RESPONSE TO REQUEST FOR INFORMATION: 90-102 REGENT STREET, REDFERN (SSD-10382)

This correspondence has been prepared by Urbis on behalf of The Trust Company (Australia) Limited ATF Wee Hur Regent Trust (**Wee Hur**) and relates to the above State Significant Development Application (**SSDA**) at 90-102 Regent Street, Redfern.

It responds to a Request for Information (**RFI**) issued by the Department of Planning, Industry and Environment (**DPIE**) on 17 March 2021. DPIE requested responses to additional submissions by NSW Environment, Energy and Science Group (**EES**), Sydney Metro, City of Sydney and two organisations following their review of the Response to Submissions (**RtS**) report submitted by Wee Hur on 1 March 2021.

Proj No. 19026
Drawing Title
GROUND FLOOR PLAN

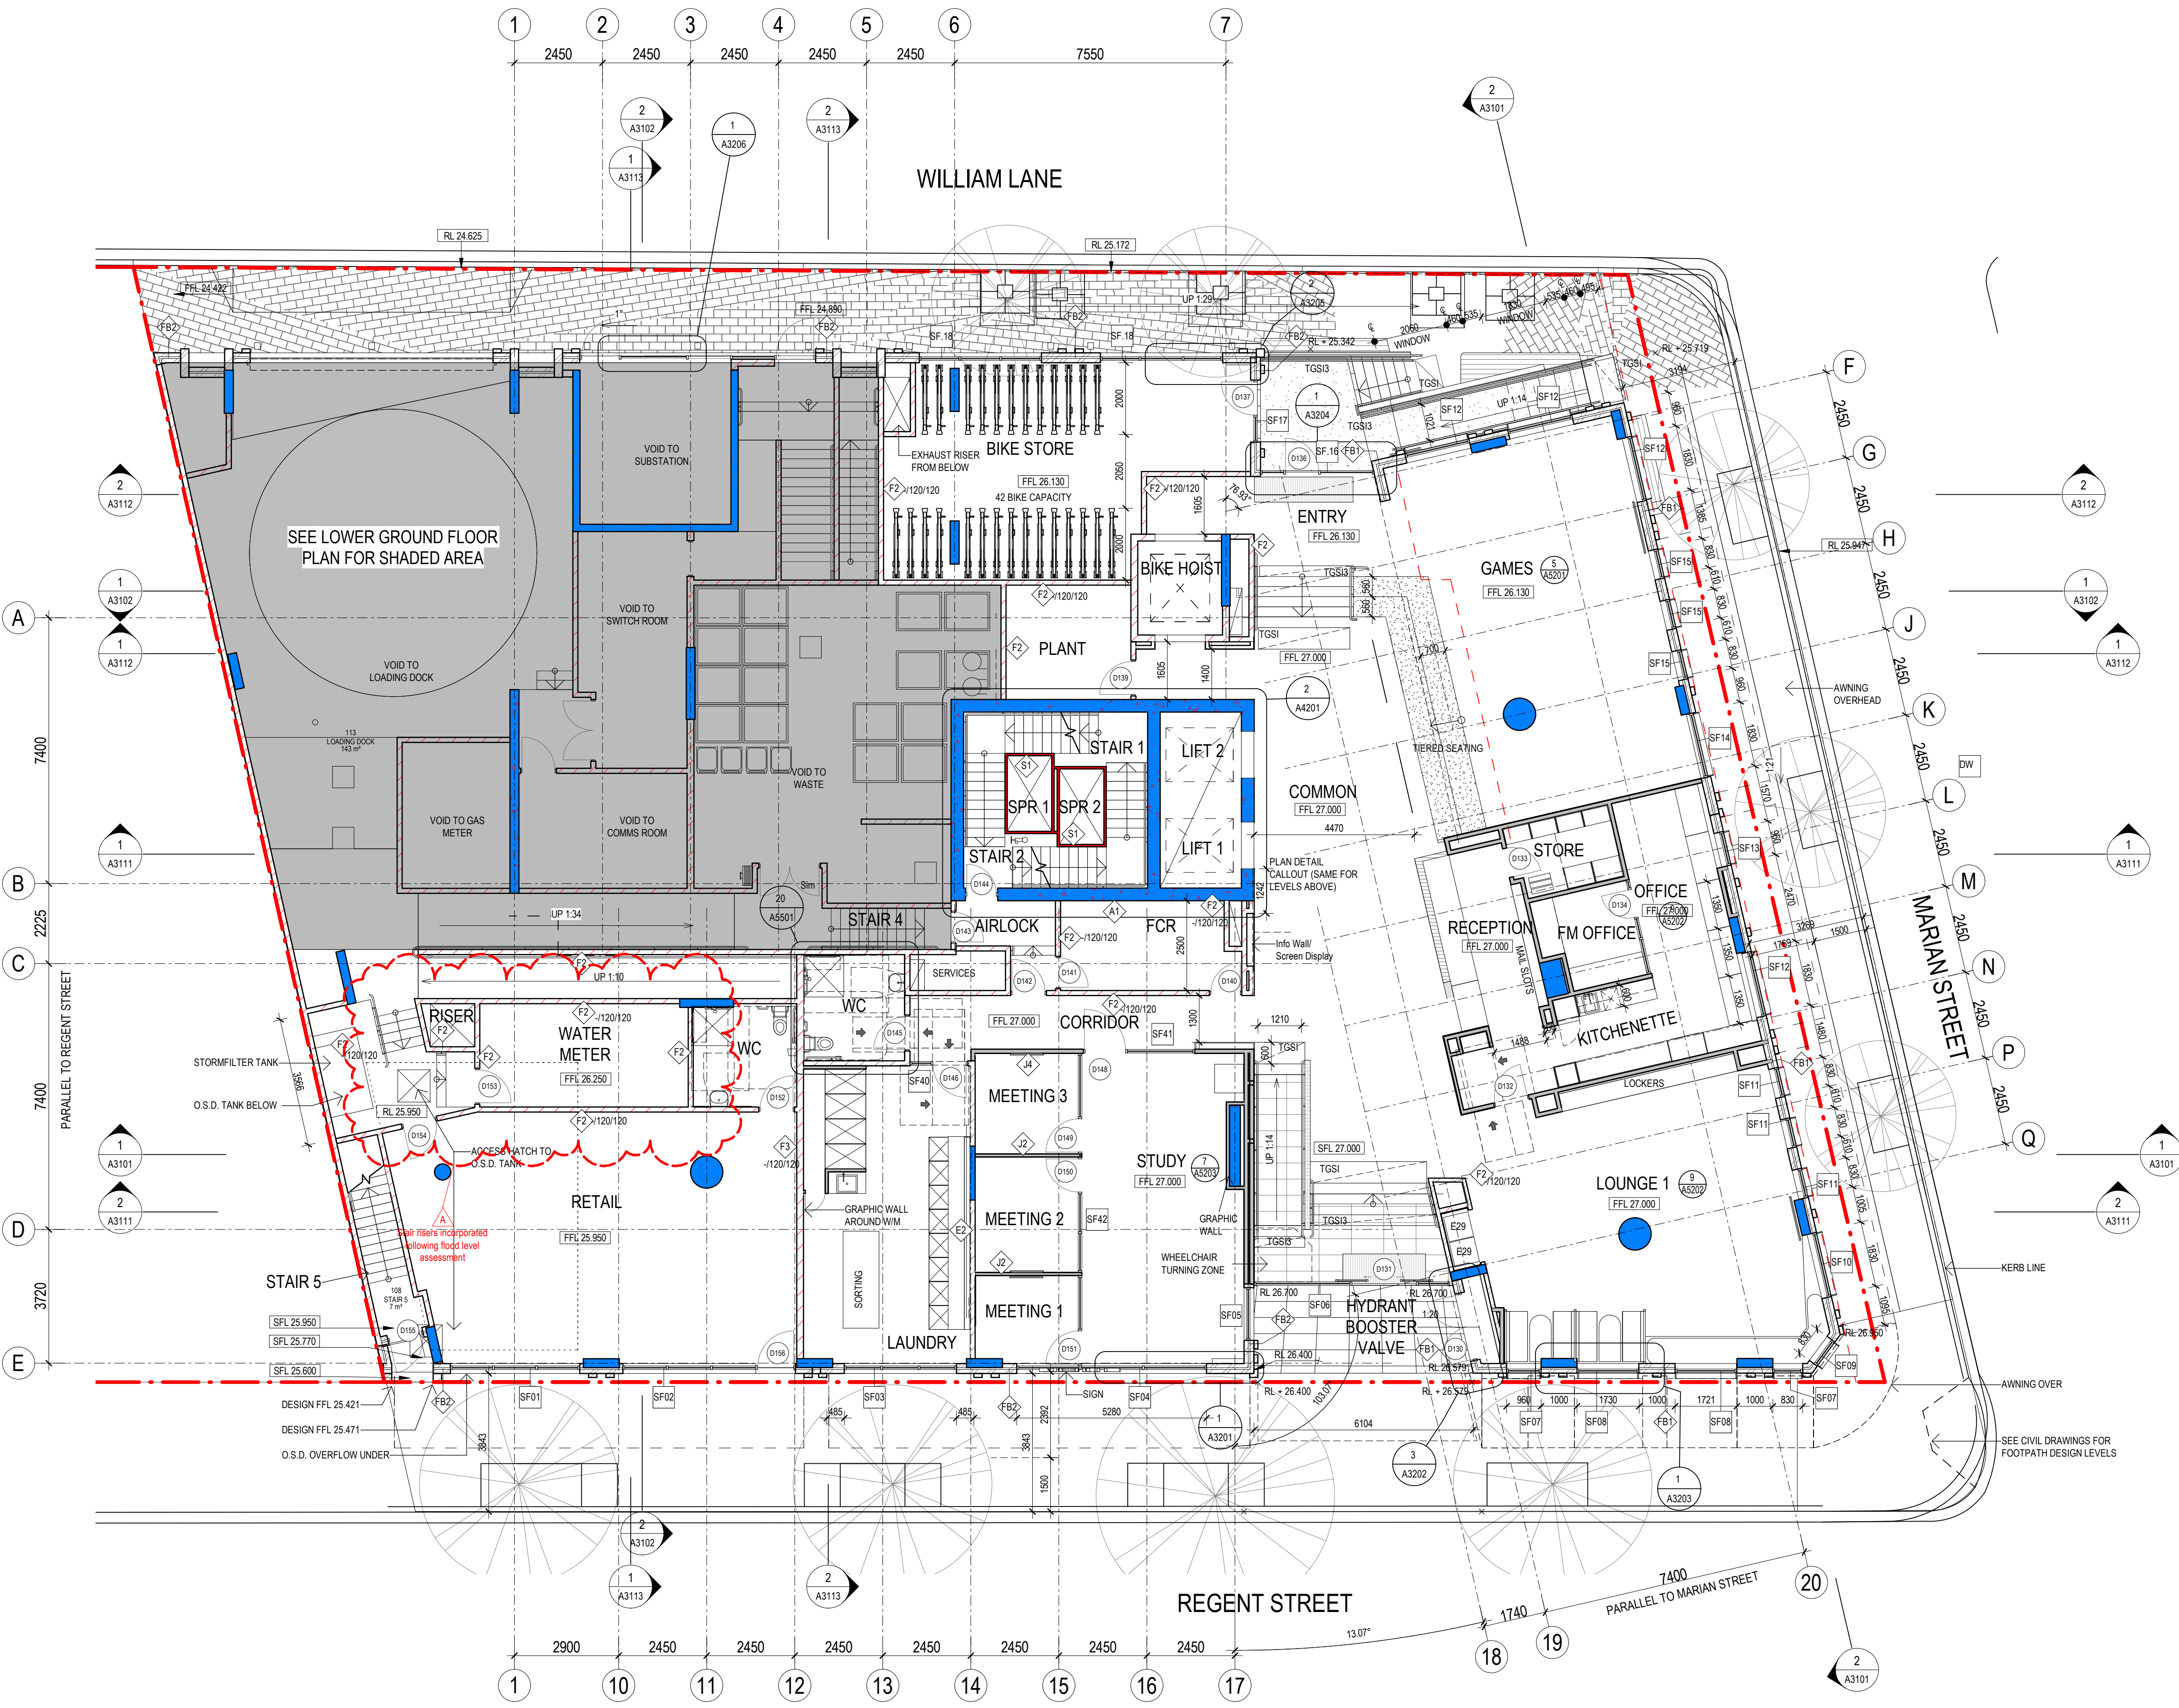
Item	Issues	Action/ Response
1	<p>Entries to basement - all entry points to the basement, including any vents, must be above both the PMF level and the 1% AEP flood level plus 500 mm freeboard.</p> <p>The staircase and loading dock entrances to the basement have levels above the PMF level but must also be above the 1% AEP flood level plus 500 mm freeboard.</p>	<p>JHA had ongoing email discussions with EES from 17 March 2021 to 9 April 2021 to resolve and satisfactorily respond to the issues raised regarding flooding. It was agreed the PMF level does not overtop the entry into the basement at the fire stairs or via the loading bay. Further, the lots are not subject to flood related development controls, as outlined in the S10.7 Planning Certificates. Accordingly, it was agreed the freeboard requirements to the 1% AEP flood level could be reduced from 500mm to 300mm to assist the architectural design at the following basement access points:</p> <ul style="list-style-type: none"> William Lane - Fire stairs to basement (left and right) Entrance to basement from loading bay <p>JHA has updated the flood planning table (Appendix Z01) within their updated Flood Assessment Report which is submitted with our updated response (Appendix E). The report confirms the proposed levels are</p>

Item	Issues	Action/ Response
		<p>appropriate based on the S10.7 Planning Certificates, a 1% AEP shallow flow depth (less than 300mm) within the roadway and restrictions associated with providing accessibility from the back of footpath to the fire stair locations. All entry levels to the basement areas are above the PMF event.</p> <p>AJ+C has updated their drawing set (Appendix A) to align with the updated flood planning table.</p>
2	Comms, Gas and Water meter room - this level is above the 1% AEP flood level, but also needs 500 mm freeboard thereto.	<p>JHA has updated the flood planning table (Appendix Z01) within their updated Flood Assessment Report (Appendix E) to incorporate the freeboard measures, which is submitted with our updated response.</p> <p>AJ+C has also updated their drawing set (Appendix A) to align with the updated flood planning table.</p>
